Planning Application Response

Local Authority:	Barnsley
Detail:	MU1 –Hybrid application for employment development, land to the south east of Higham Common Road
Planning Ref:	2021/1089
Deadline:	20 th October 2021
Submitted by	██████████, Trans Pennine Trail Officer

Figure 3 – Illustrative Masterplan

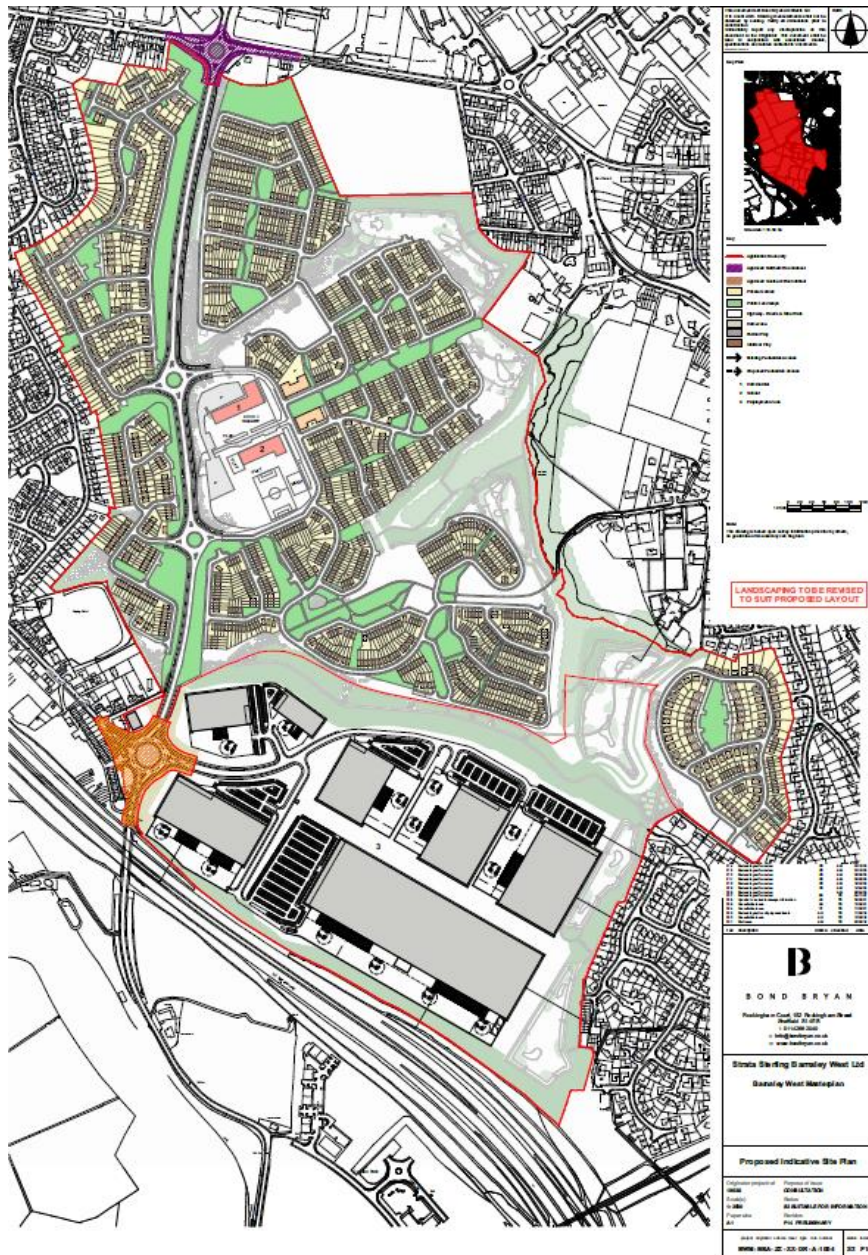
The key shows no indication of including cyclists within the development:

The Masterplan should be amended to clearly identify all cycle routes and access / egress locations.

In terms of employment facilities, cycle parking should also be clearly indicated on the plan.

2.1	Notes intention to make sustainable travel practical and attractive but yet the Illustrative and Landscape Master Plan Drgs do not indicate any cycling provision.

4.2	<p>All drawings should clearly indicate access points and routes for walkers and cyclists. This is currently not the case on the Illustrative and Landscape Masterplan drgs noted earlier.</p> <p>Clear signage is paramount for sustainable transport users. Signs should include user symbols and destination distances. Routes to the wider network should also be signed.</p> <p>Link Road: the walking and cycling provision should meet LTN1/20 standards as a minimum. Detail should be provided on the types of crossings proposed for the link road for walkers and cyclists.</p> <p>Phase 1: refers to pedestrian access points – such access points should be provided for both walkers and cyclists.</p> <p>Development Plots: Notes new pedestrian infrastructure and then notes cycle parking. This section needs to be amended to state walking and cycling, not just one mode.</p> <p>Table 4: 1 – Notes pedestrian routes will be provided – routes should be for walkers and cyclists not just pedestrians. 4 – Cycle parking should include facilities for cycles of all abilities. 8 – Why are attack alarms only to be provided for those wishing to walk to work and not all staff?</p>
